TfNSW Reference: SYD20/00731/02

DPIE Reference: SSD-10474

EXHIBITION OF EIS - ST MARYS RESOURCE RECOVERY FACILITY - 25 DUNHEVED ROAD, ST MARYS

Figure 2.4: Peak Hourly Traffic Turning Movements (2020)

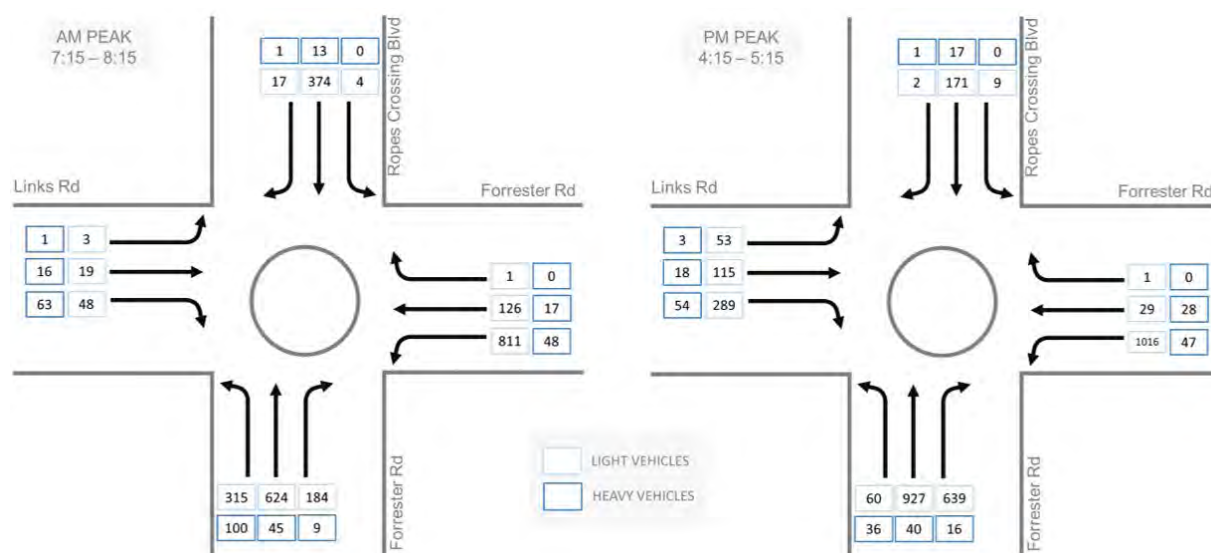
3. The TIA uses traffic survey data undertaken in 2016 which is outdated. It is not clear why more recent traffic survey counts were not undertaken.
4. A Construction Pedestrian Traffic Management Plan (CPTMP) detailing construction vehicle routes, number of trucks, hours of operation, access arrangements and traffic control should be submitted to Council for approval prior to the issue of a Construction Certificate.

Figure 4.1: Trip Generation Comparison

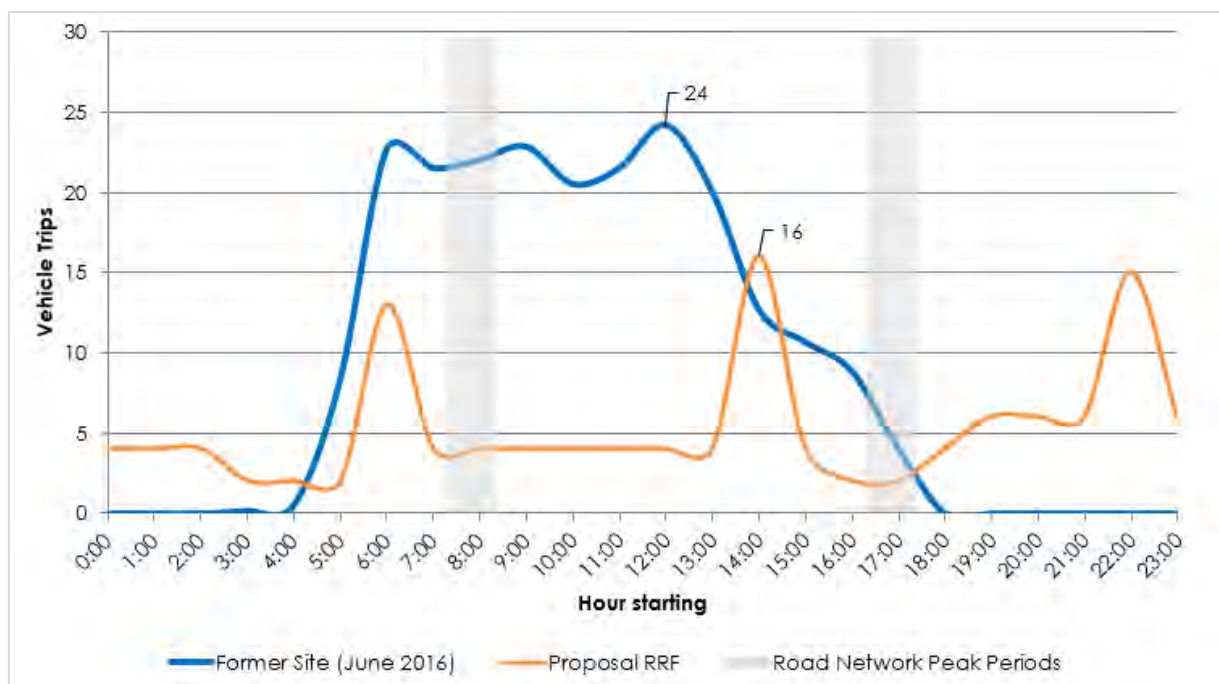
2. The TIA states that the proposal will generate 92 one-way heavy vehicle trips per day, but does not break down this figure into the number generated by inbound (mostly heavy rigid vehicles), or outbound vehicles (mostly semi-trailers).

It is requested that the proponent detail how the daily heavy vehicle trips were calculated, and show that the number of heavy vehicle trips can handle the proposed throughput of 150,000 tonnes per annum.
